In future correspondence please refer to:
Project Tracking Code: 2021-04-02040
Property: Kittitas County_Demarest Shoreline Stabilization Project (SX-21-00003)
Re: Monitoring Requested

RE: SX-21-00003 Demarest

Re: SEPA Register 202101587, SX-21-00003

TO: All Staff
FROM: Public Works Planning Review Team
DATE: April 13, 2021
SUBJECT: SX-21-00003 Demarest

JANUARY 2021
 YAKIMA RIVER AT DEAREST PROPERTY
 830 PEBBLE BEACH DRIVE, CLE ELLUM
 BANK STABILIZATION SITE PLAN
 DRAWING 2

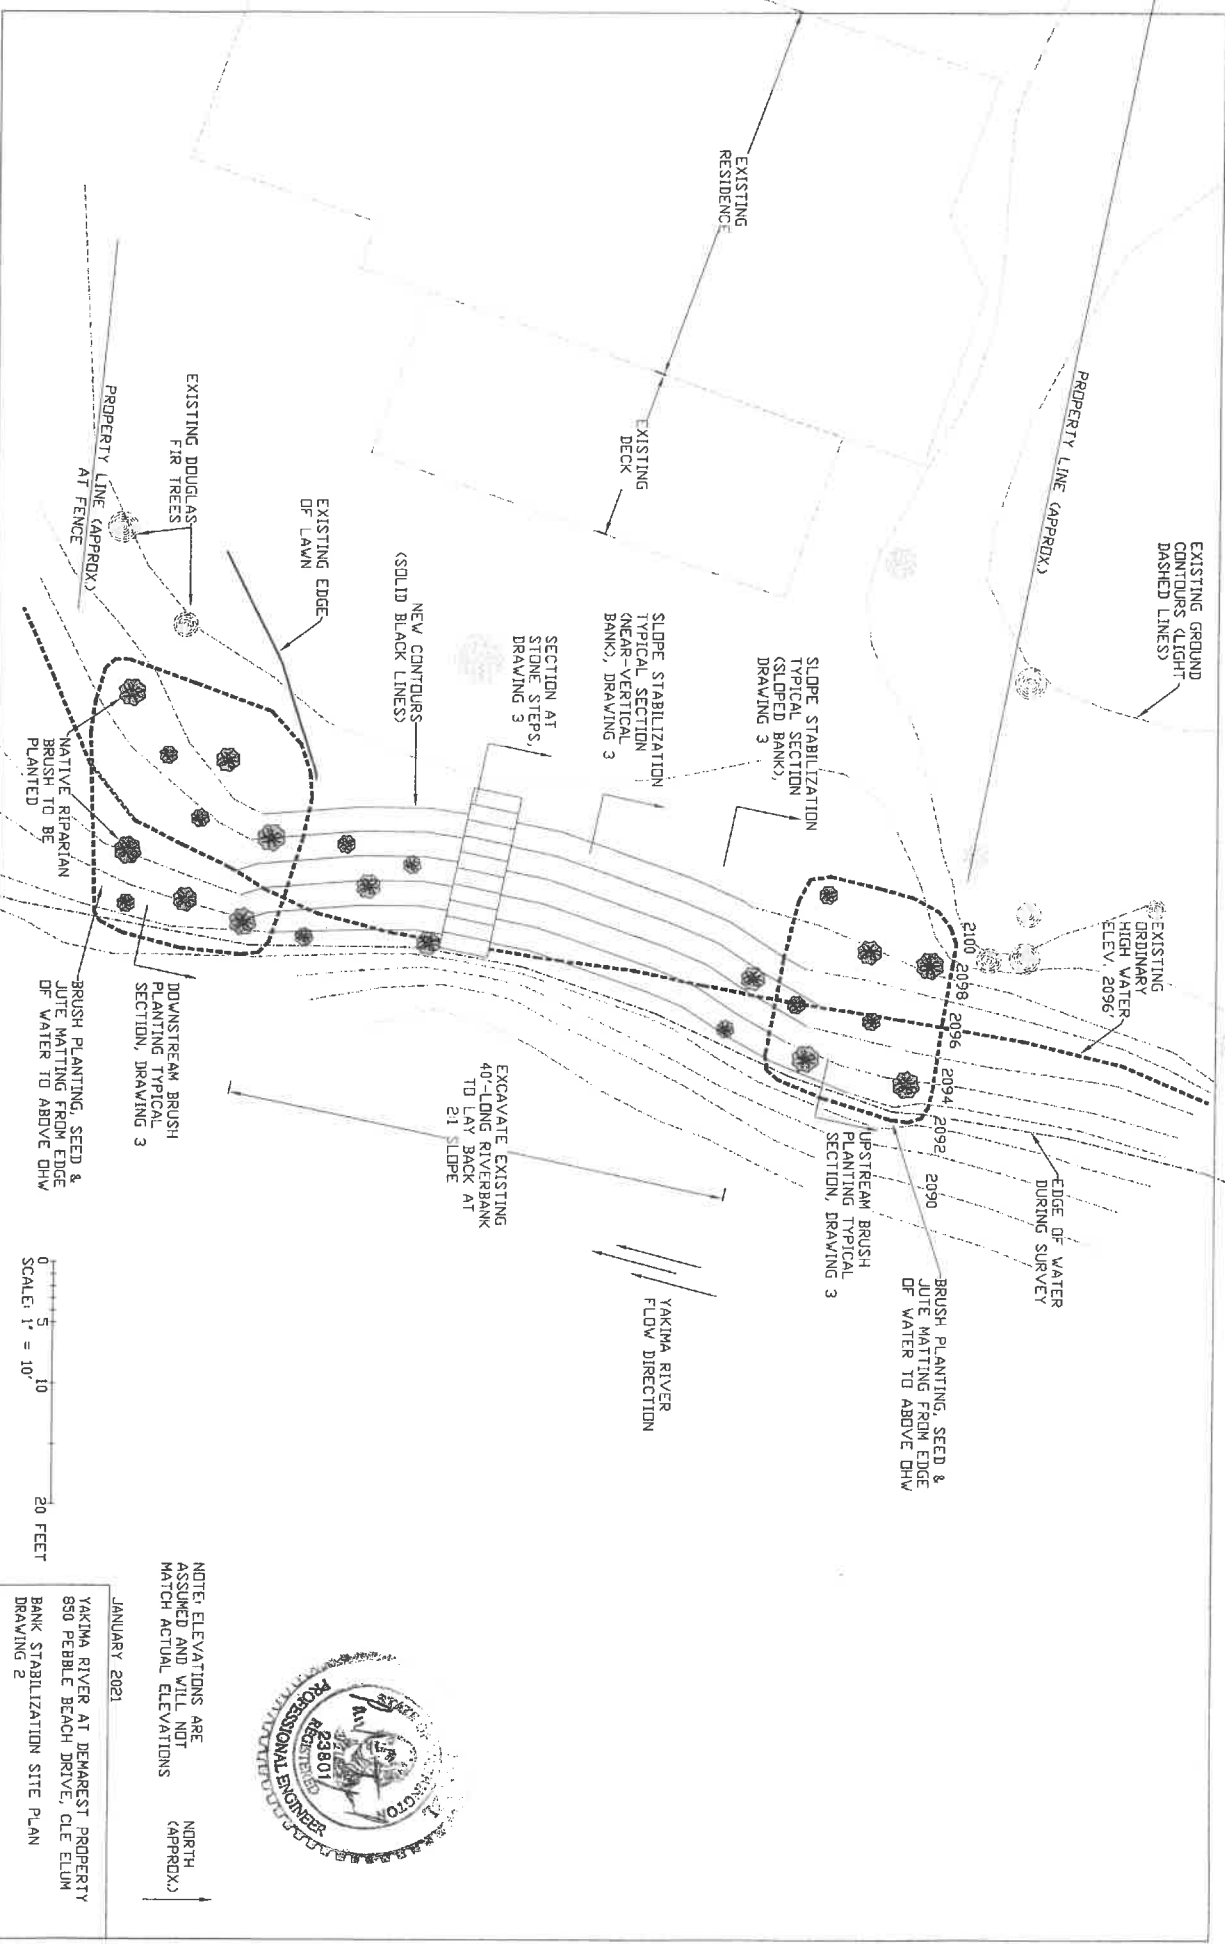
Ecology recommends the County requests a more detailed planting plan to ensure the bioengineered bank stabilization is successful. Ecology staff would be happy to review any planting plans associated with the bank stabilization project. Should you have any questions regarding these comments, please contact **Lori White** at (509) 575-2616 or lori.white@ecy.wa.gov.
